**Our ref:** HA/2019/121101/01-L01  
**Your ref:** CM/4/19/PL  
**Date:** 01 March 2019

**Construction of a crematorium comprising of a crematorium building & associated structures, car parking, access & landscaped spaces. This application is a departure from the development plan**

**Land South of the A259, Grevatt's Lane, Climping, BN17 5RE**

Thank you for consulting the Environment Agency on the above application.

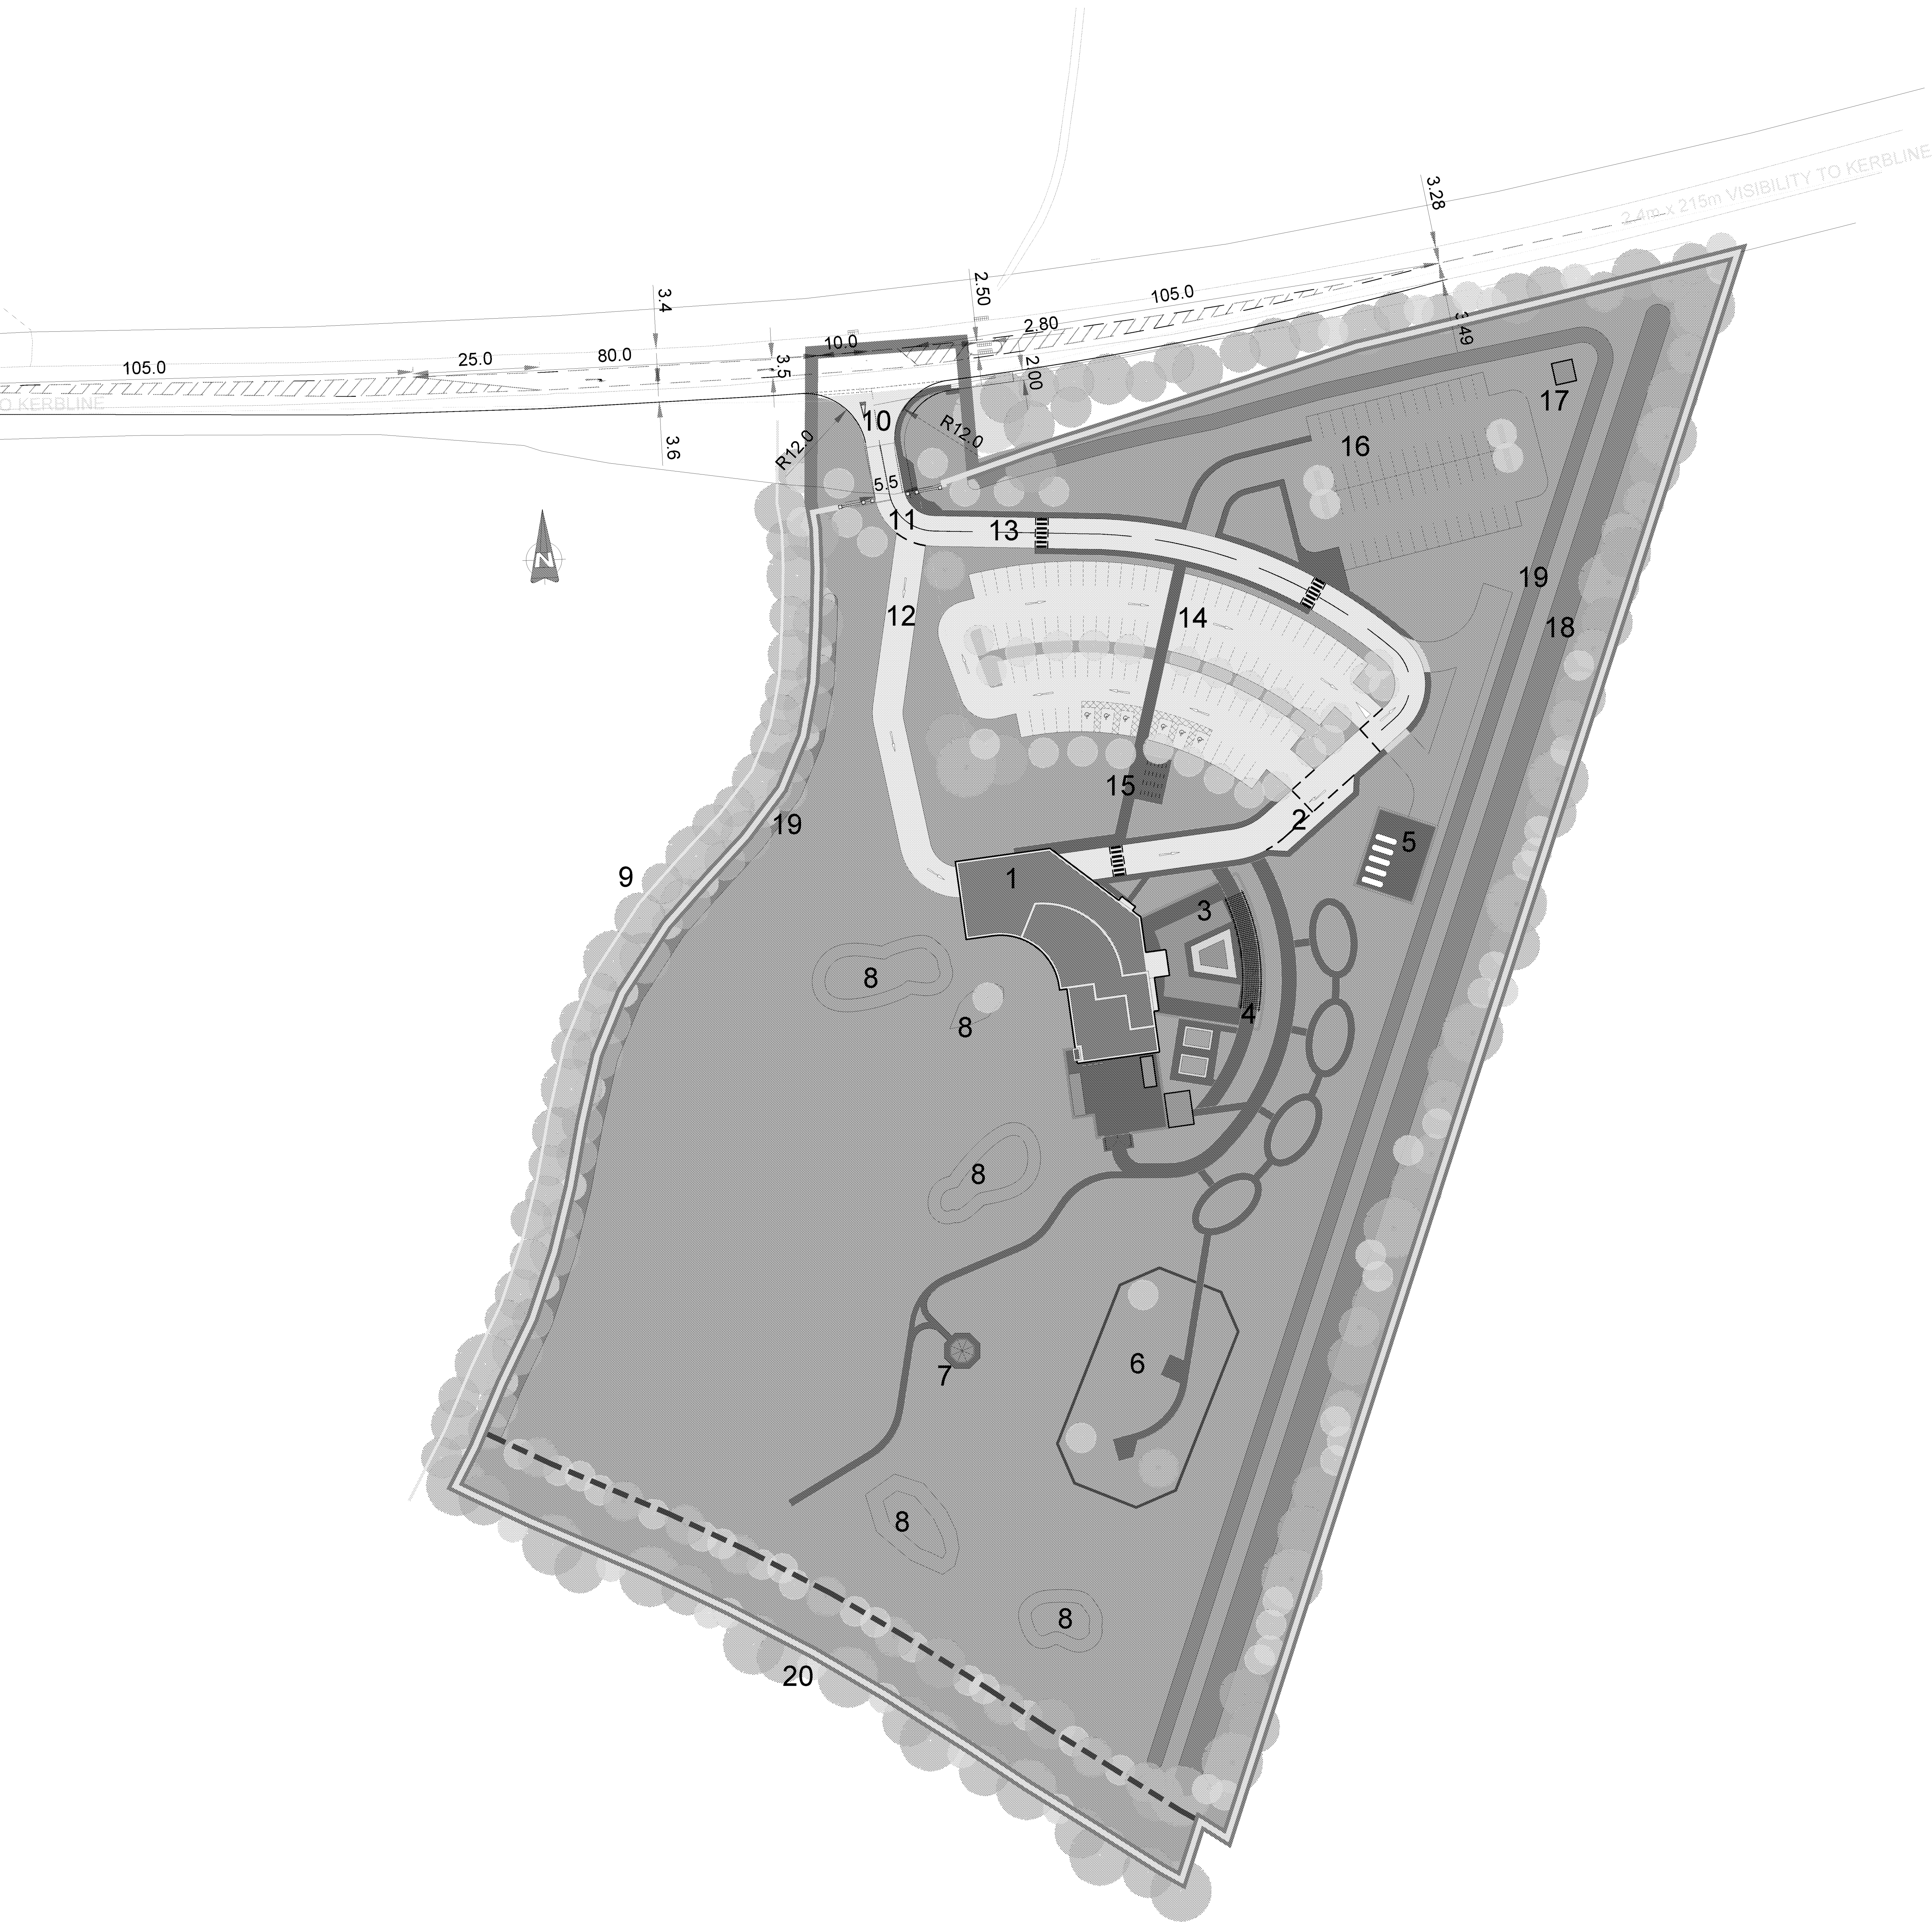
Similarly to the west of the site there is an 'ordinary watercourse'. It is noted that the site entrance will need to cross this watercourse, and there are also proposals to construct a new ditch on the layout plan SC-CLMPG-V1-XX-DR-K-0500, for which the detail is unclear.

Any works in under or over the said ditch or within 3-5metres from the bankside edges, a flood Defence consent will be required from the Lead Local Flood Authority (LLFA)
